Office of
Environment
& Heritage

RE: REVIEW OF ENVIRONMENTAL ASSESSMENT FOR NORTHBANK ENTERPRISE HUB (MP 10_0185), TOMAGO

ATTACHMENT A: OEH REVIEW – OUTSTANDING ISSUES

Figure 7-1 7-day High Flow Duration Frequency Curves

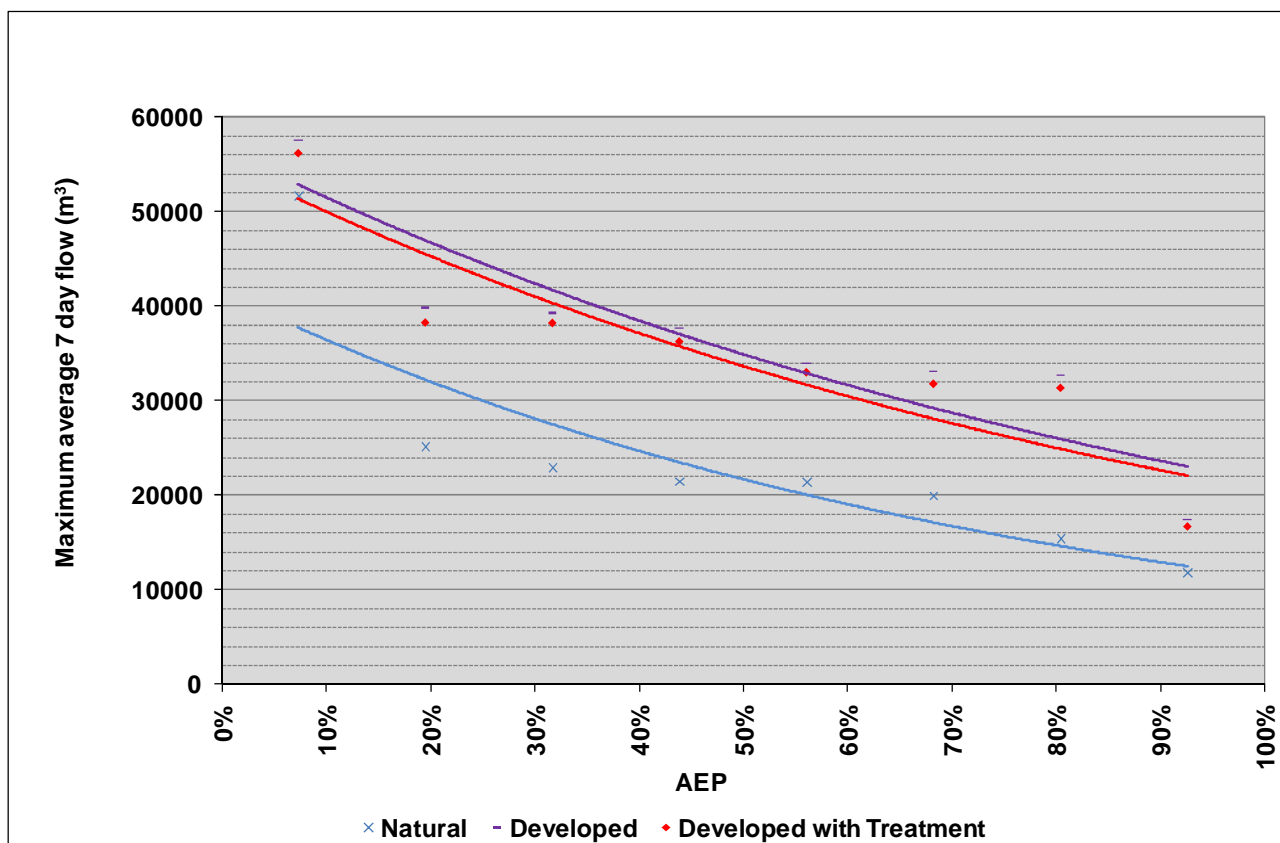
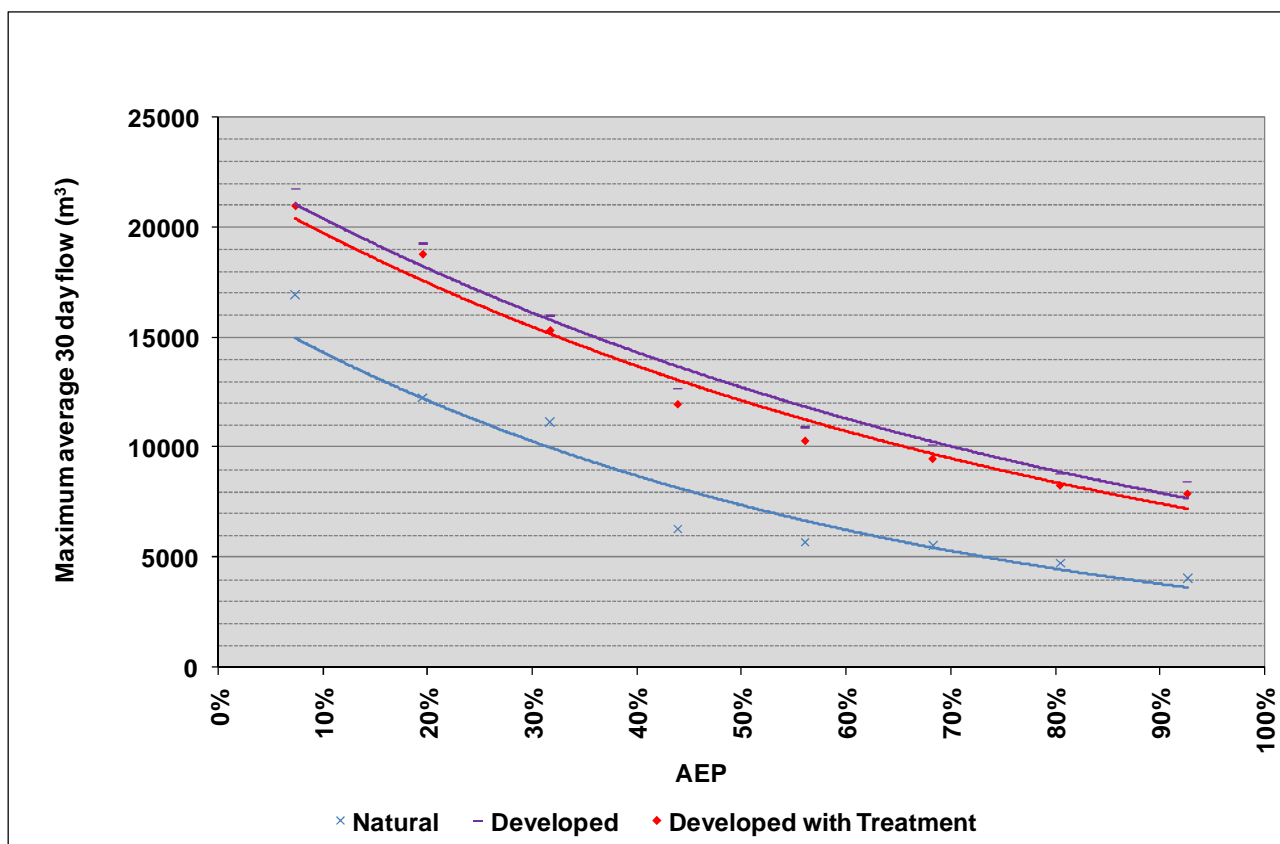
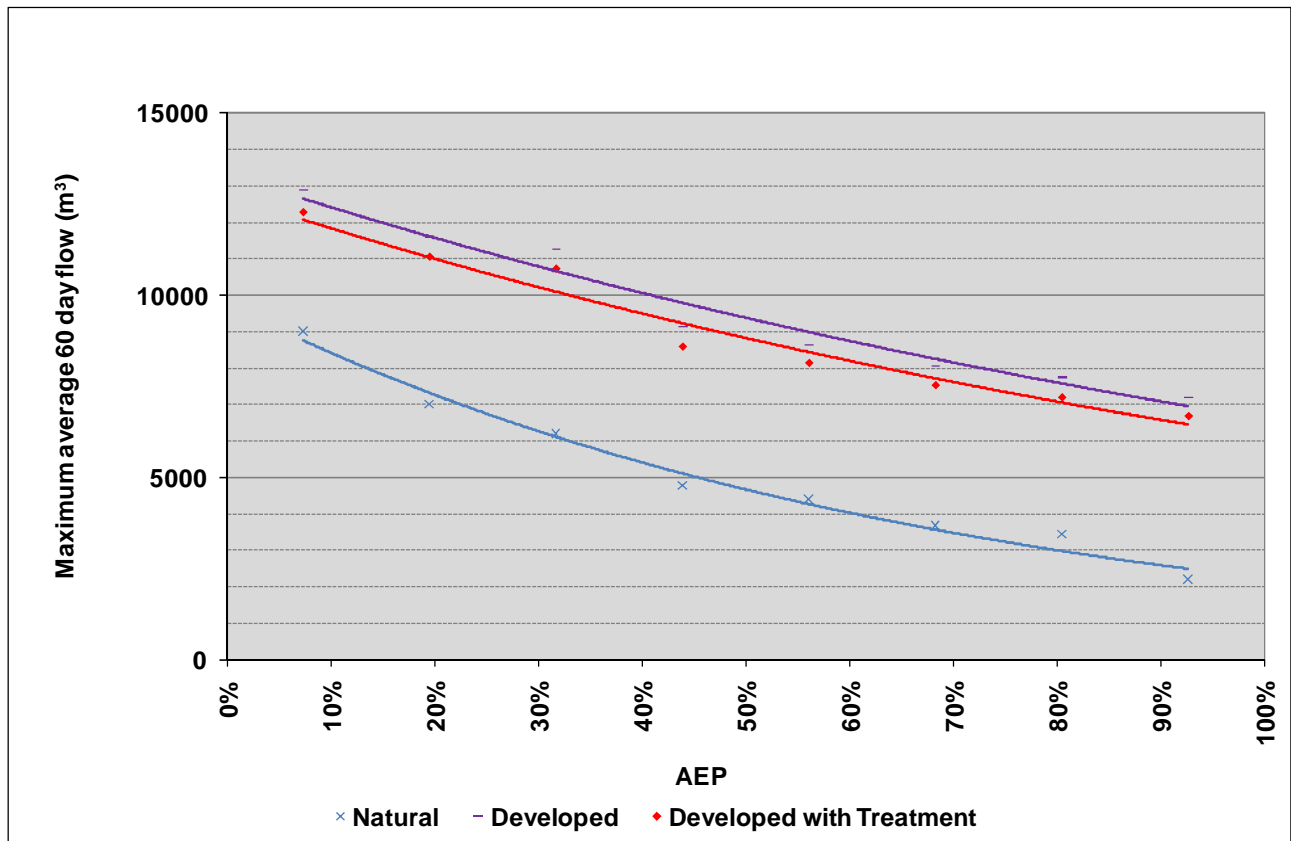
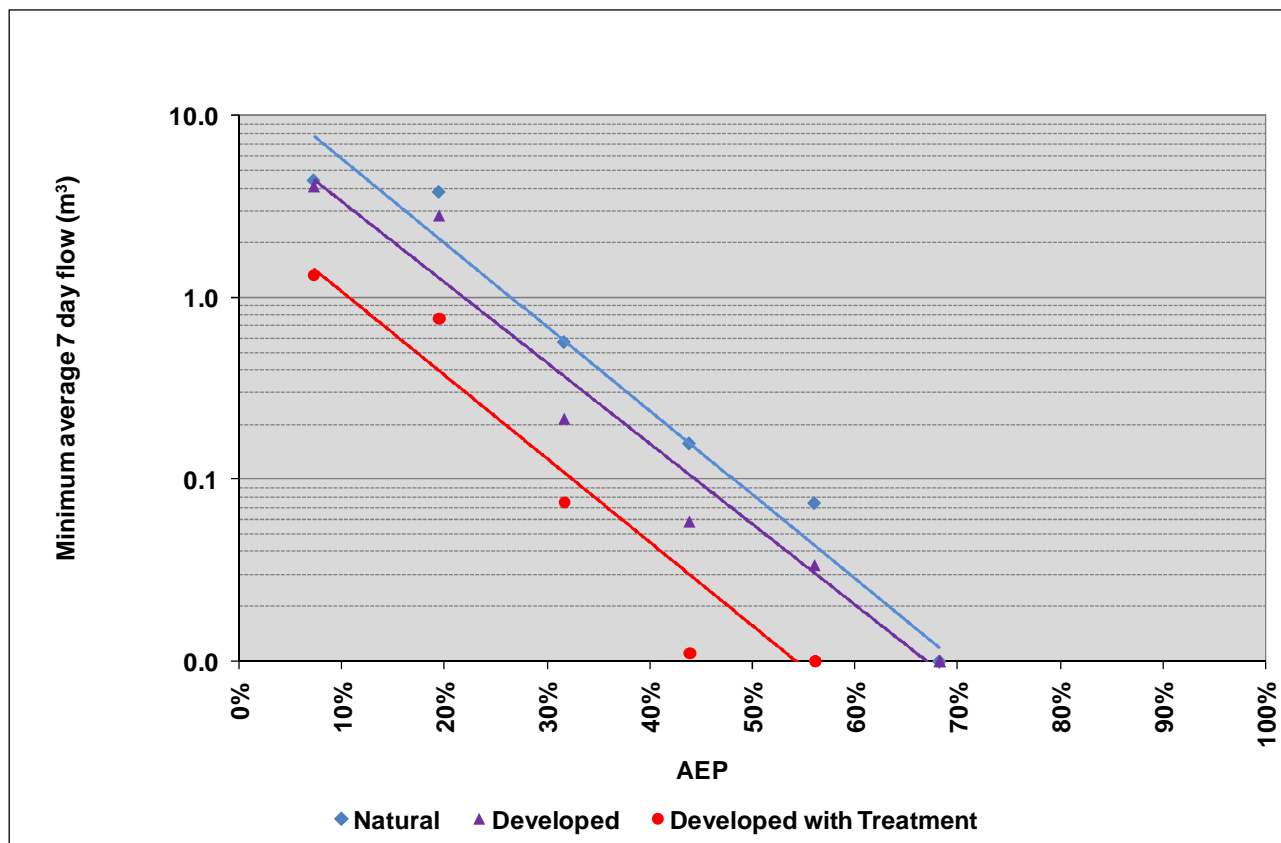
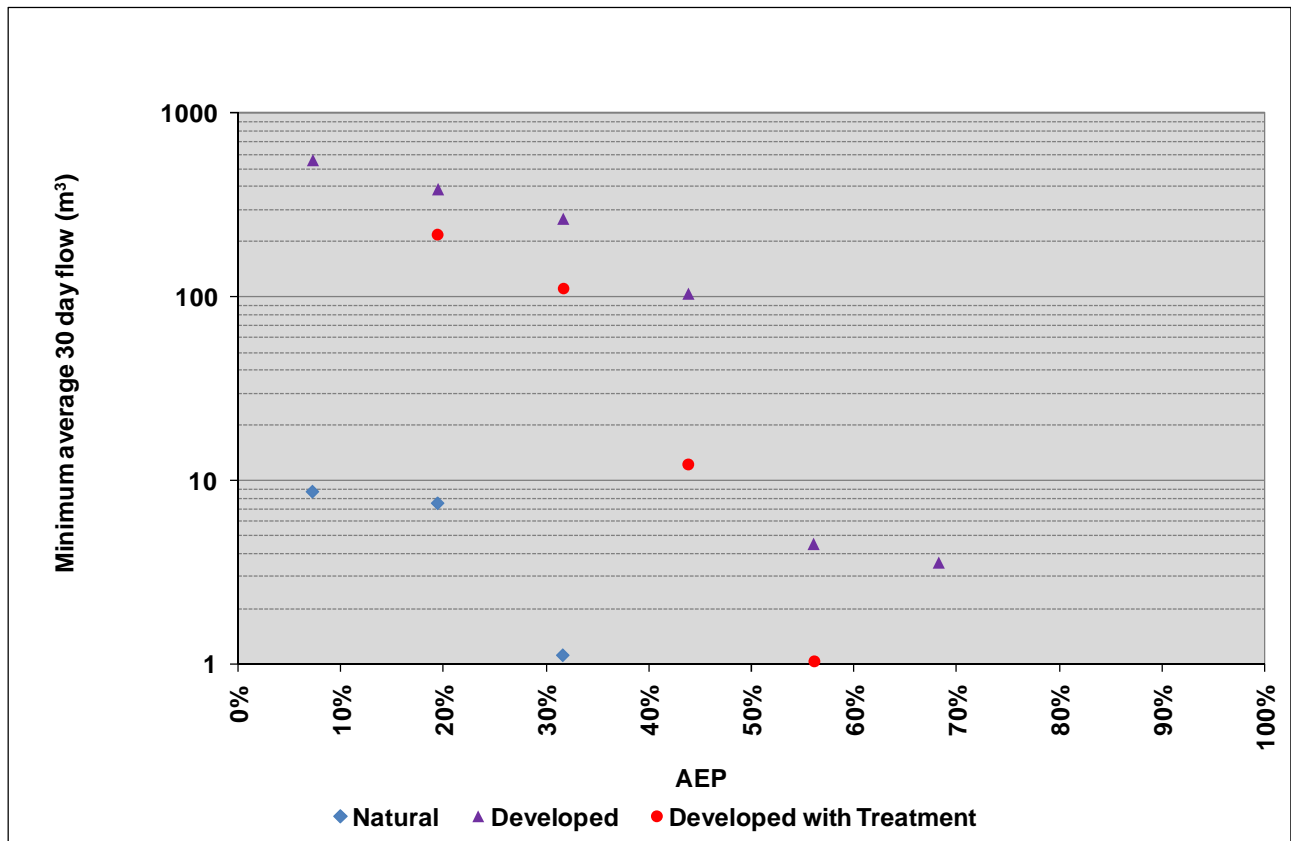
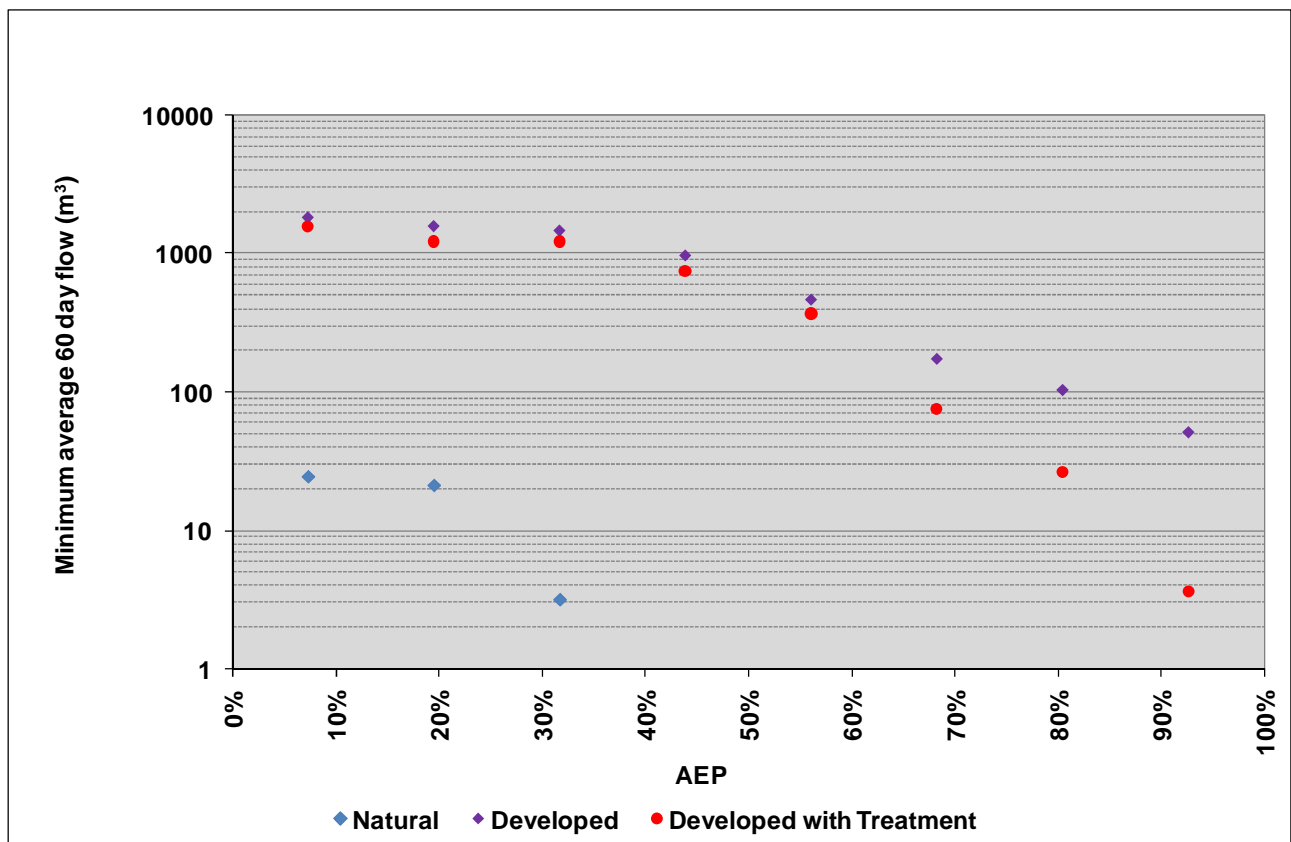
This is especially important considering the information shown in Figures 7-1 – 7-6, as they indicate that the post development stormwater runoff regime from the site is considerably different to the existing regime.

- a) Section 7.2 states that low and high flow duration frequency curves were plotted for each site, however only one site has been reported. Either the text in the report needs updating, or additional graphs need to be included in the report.
- b) Figures 7 -1 – 7-6 – The information contained within these figures indicates that there will be a dramatic increase in all of the high and low flow duration scenarios from existing conditions (7-day, 30-day and 60-day), even with mitigation options in the post-developed scenario. The post-developed scenario needs to mimic the existing runoff regime as closely as possible, so as to minimise the disturbance on the receiving environments. As mention above in point 1-3, the site is surrounded by wetlands; EEC's; a wetland, and an ecological offset area, therefore it is imperative that hydrological disturbances to these ecosystems are minimised.

The current stormwater drainage system proposal (assumed to include bio-retention swales, grassed swales, and bunded area) indicates that the low flow duration frequency for all events modelled (7-day, 30-day and 60-day) is between 2 and 4 times greater than existing conditions. This could have long-term adverse impacts on the wetlands to the east and south-east which are currently undergoing rehabilitation from freshwater wetlands to saltwater wetlands by the National Parks and Wildlife Service.

- c) Page 95 states that “*mitigation includes maintaining hydrology of surface runoff after land filling both during and after the construction phase of the proposed development*”. As mentioned above, the results included in Figures 7 -1 – 7-6 of the Stormwater Assessment report indicate that this is clearly not the case.
